Town & Country Planning (Control of Advertisement) (England) Regulations 2007 (as amended)

Application No: Y/107/20/A
Site Address: Land to the south of Ford Lane /East of North End Road Yapton BN18 0DS
Description of works: Various non illuminated advertisements.

Thank you for your internet representation made on 13th November 2020 which has been recorded as an objection with the comments as follows:

Development	Redrow Flag		
Drawing Title	Redrow Flag	Drawing No.	REDFL-001
Date of Issue	16/7/18	Revision	A
		Scale	1/20 @ A4

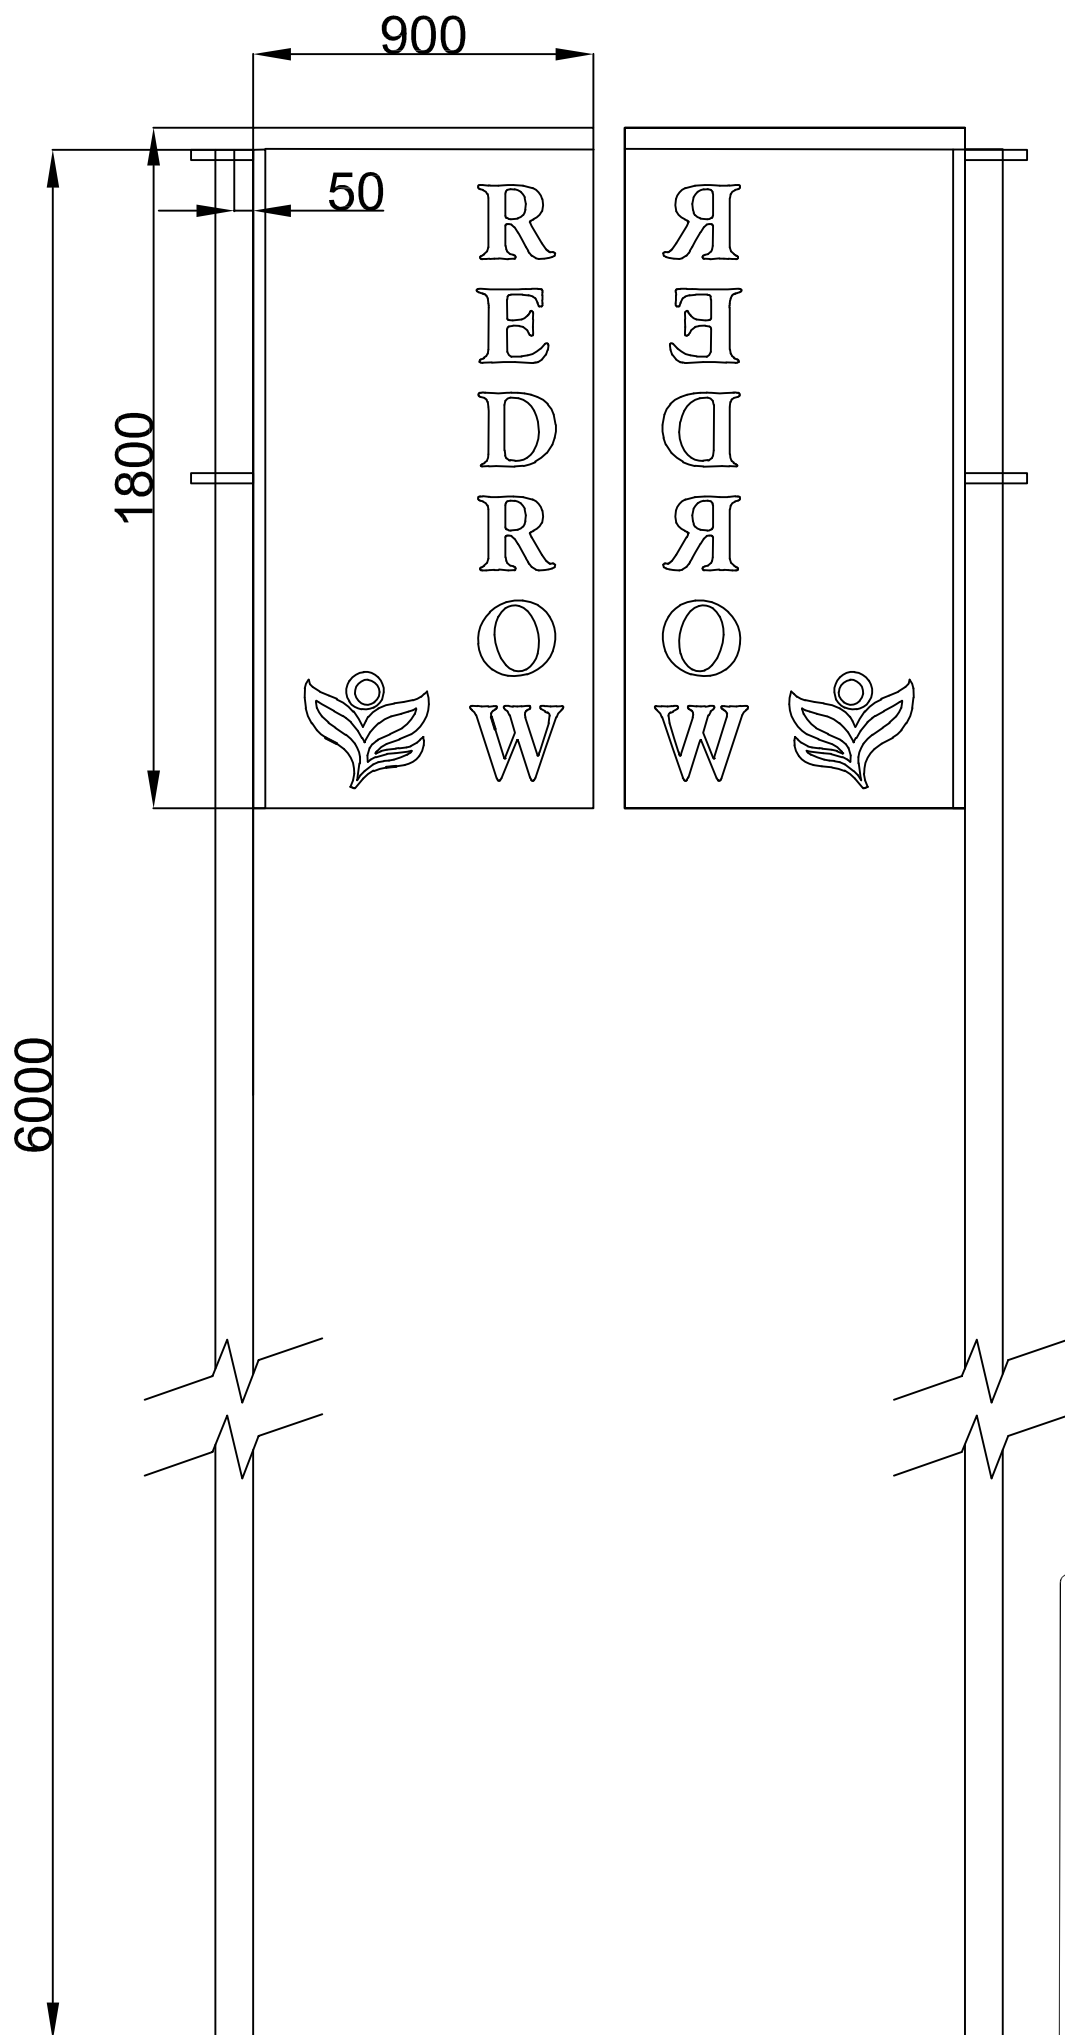
YPC has fully considered the above planning application and would like to express its strong objection the excessive proposed use of 7 marketing flags in and around the temporary customer parking area.

YPC recognise the need for any company to market its product but believe this excessive use of flags to be inappropriate for such a rural location especially Ford Lane, an unclassified road. It should be noted that the noise generated by these flags will have a negative impact on nearby property.

YPC would ask that the applicant re-submit a more sympathetic proposal omitting flags.
